MARINE AND COASTAL ACCESS ACT (2009). APPLICATION FOR A MARINE LICENCE BY MONA OFFSHORE WIND LIMITED FOR THE CONSTRUCTION AND OPERATION OF THE TRANSMISSION ASSETS FOR MONA OFFSHORE WIND FARM OFF LLANDDULAS NORTH WALES EAST IRISH SEA.

Reference Number: ORM2429T

From: Sylvia Blake
Cefas, Lowestoft Laboratory
Date: 13th August

To: Peter Morrison - NRW (via email)

Figure 1.1: Location of proposed Mona Offshore Cable Corridor disposal site.

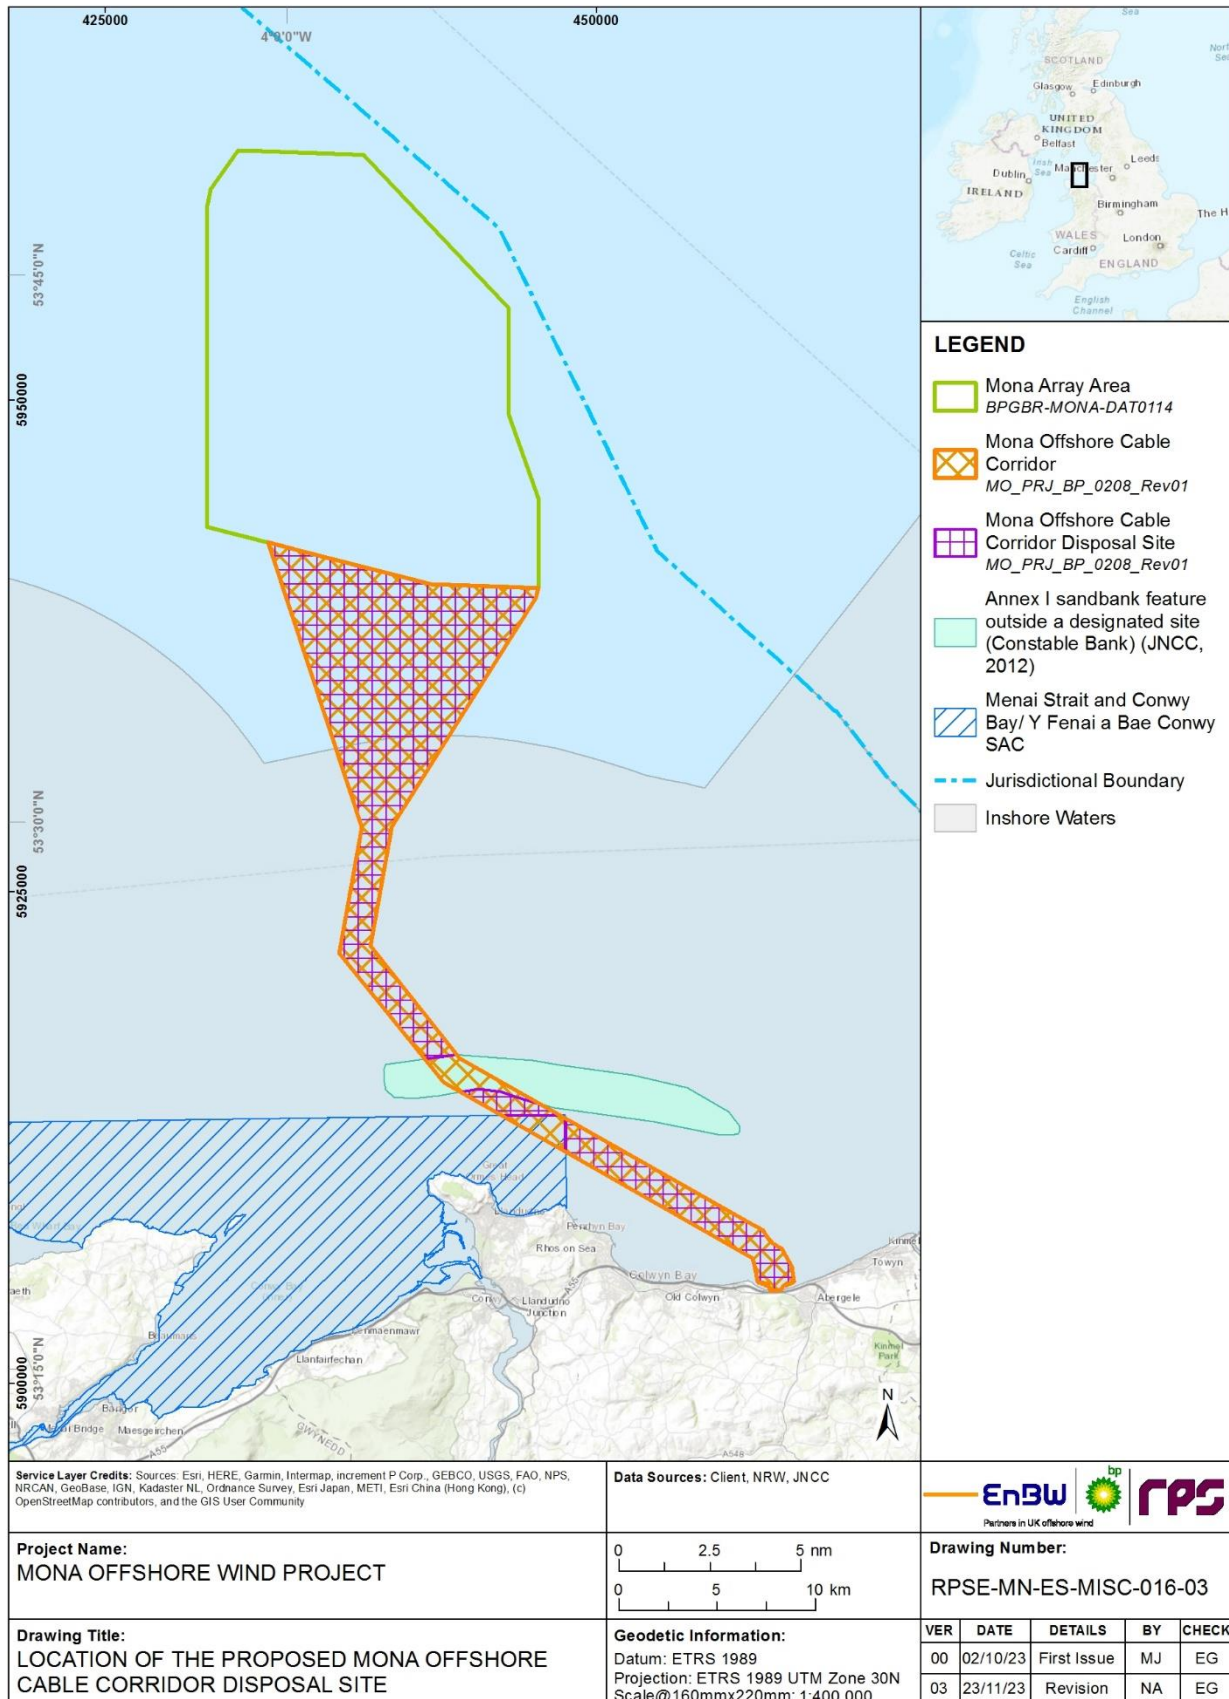
32. **Minor comment (Action):** Plotting the area of the disposal sites from the co-ordinates provided in the shape file show the offshore cable corridor to be split into 3 areas (figure 3) however the figures in the characterisation reports (documents 8 and 9 figures 1 and 2 copied in Annex 1 below) show the area of the offshore cable corridor to be continuous, therefore I have assumed that the area to be designated would be continuous and the applicants shape file needs amended, unless there is a specific reason for the separation.

- 40. If NRW determine require the array area and the export cable corridor designated although there is no clear advantage of either designating these together or separately, as the applicants intend to dispose of dredged material close to the extraction site and that both areas being adjacent may find some deposition from works adjacent to their site, for efficiency the suggestion is for one disposal area to be opened if required for the sole use of the construction and operation/maintenance works at Mona to be closed upon completion of the works. The disposal site shape file should be amended for the offshore cable corridor to be continuous (as per comment 32).

Figure 1.1: Location of proposed Mona Array Area disposal site.

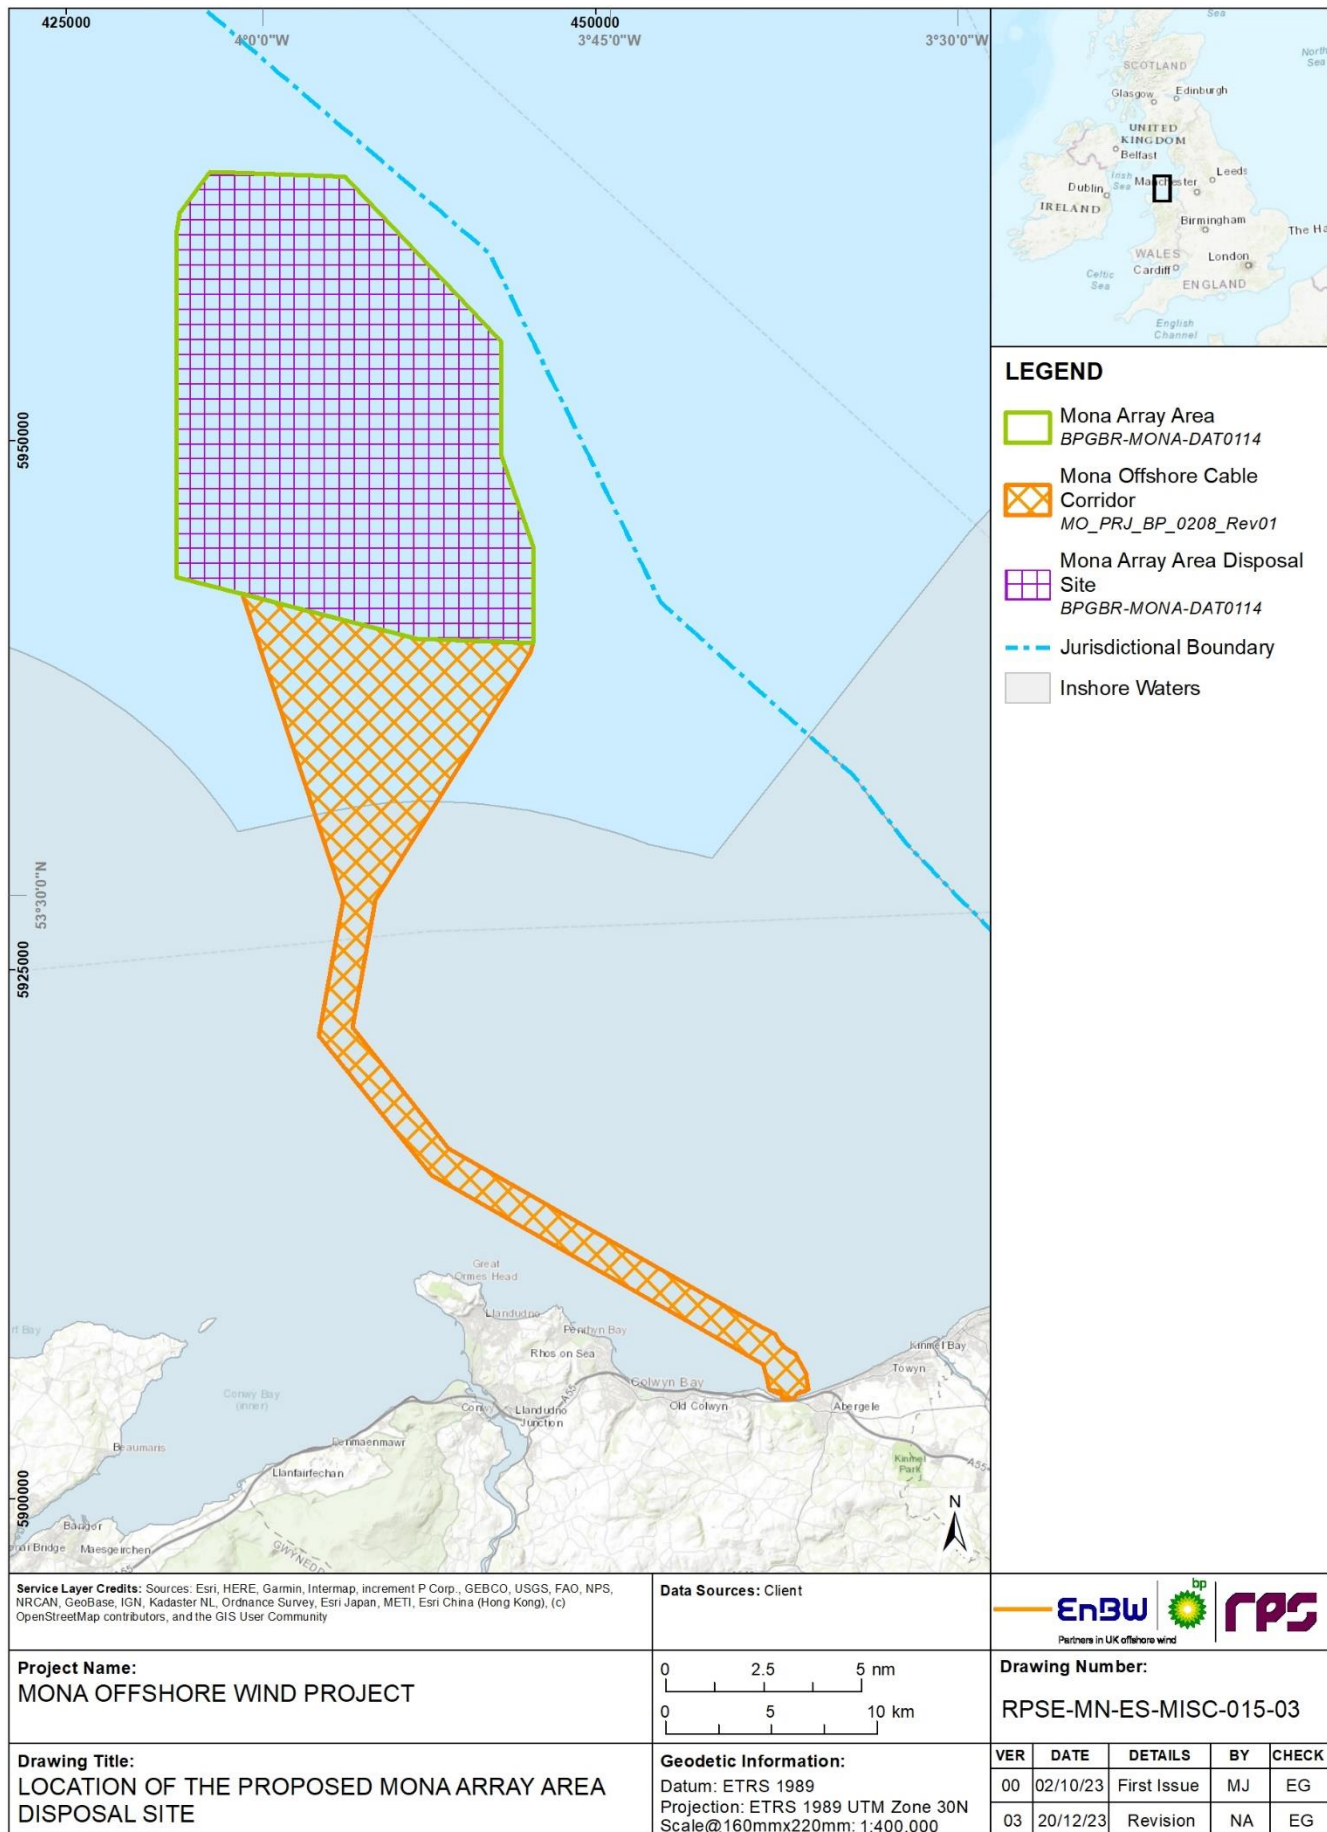
pragmatic to designate one site for both areas. (area of the array- Annex 1 figure 1, and the area of the offshore cable corridor - Annex 1 figure 2).
